Subdivision Comments

Date: 08/11/2020

RE: SP-20-00004

AIRPORT ROAD SHORT PLAT APPLICATION

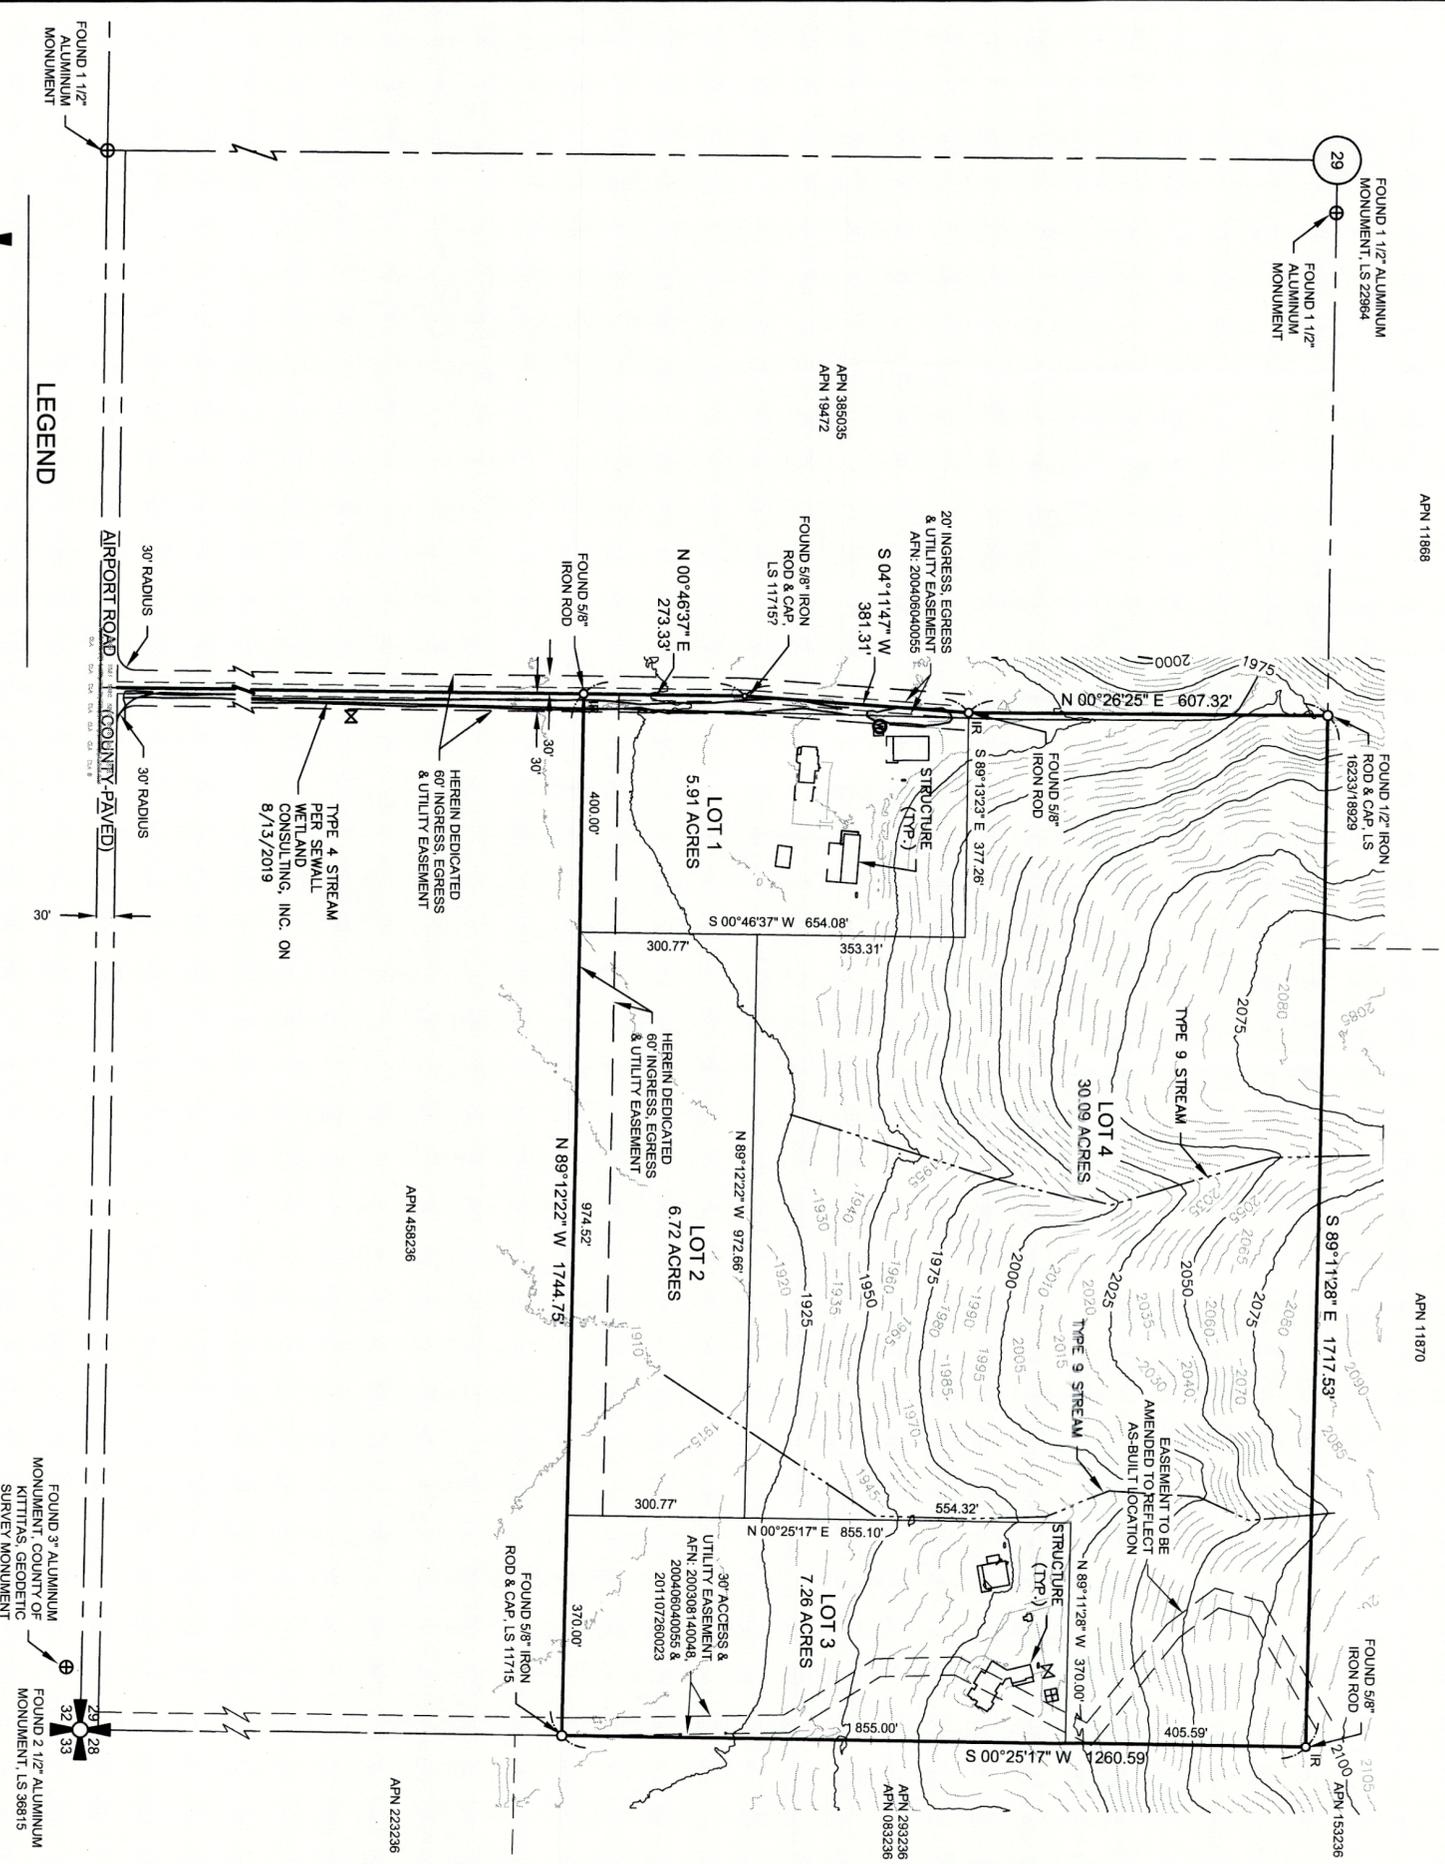
Any On-Site Septic systems that are to be utilized for wastewater management must adhere to the standards set by both the Washington Administrative Code, and Kittitas County Code. In accordance with KCC 13.04.090, a minimum of one soil log for lots 2 and 4 where individual sewage disposal systems are contemplated must be completed (see **Condition B-3**). Public Health requests clarification on the on-site sewage disposal system plan.

Proposed short plat indicates individual and shared wells will be used. If the intention is to utilize a shared well, a signed, notarized, and filed shared well users agreement will also need to be provided before the short plat is finalized. If shared wells are to be utilized, the wells must be drilled a minimum of 50 feet from any proposed property line and a signed, notarized and recorded shared waters users' agreement for each shared well must be submitted to our office prior to final plat approval. Well locations for lots 1 and 3 were not provided and will need to be indicated before final approval can be made. The applicant must prove legal and physical availability of water for all new uses of water on proposed lots of this project, which can be provided through mitigation certificates (see **Condition B-1**) and a well log or 4 hour draw down test as proof of water adequacy for each new well (see **Condition B-2**). All persons who are making applications for land use including but not limited to short plats must comply with KCC Chapter 13.35.027 per KCC Chapter 13.35.020.

B-2 13.35.020(b) requires proof of adequate water supply, which can be submitted through a well log or 4 hour draw test result. If shared wells are used, a signed, notarized, and recorded shared well-users agreement must be submitted. All individual and shared wells must meet the distance requirement of 50 feet from the property line, 50 feet from the septic tank and 100 feet from the drain field as per Kittitas County Critical Areas Ordinance 17A.08.25, and KCC Chapter 13. Locations of wells on lots 1 and 3 must be provided.

B-3 Soil logs are required for lots 2 and 4. In accordance with KCC 13.04.090, a minimum of one soil log for each proposed lot where individual sewage disposal systems are contemplated must be completed prior to final plat approval. Soil logs can be scheduled at <https://www.co.kittitas.wa.us/health/septic-inspection.aspx>. Soil logs are performed in accordance with Washington Administrative Code 246.272A.
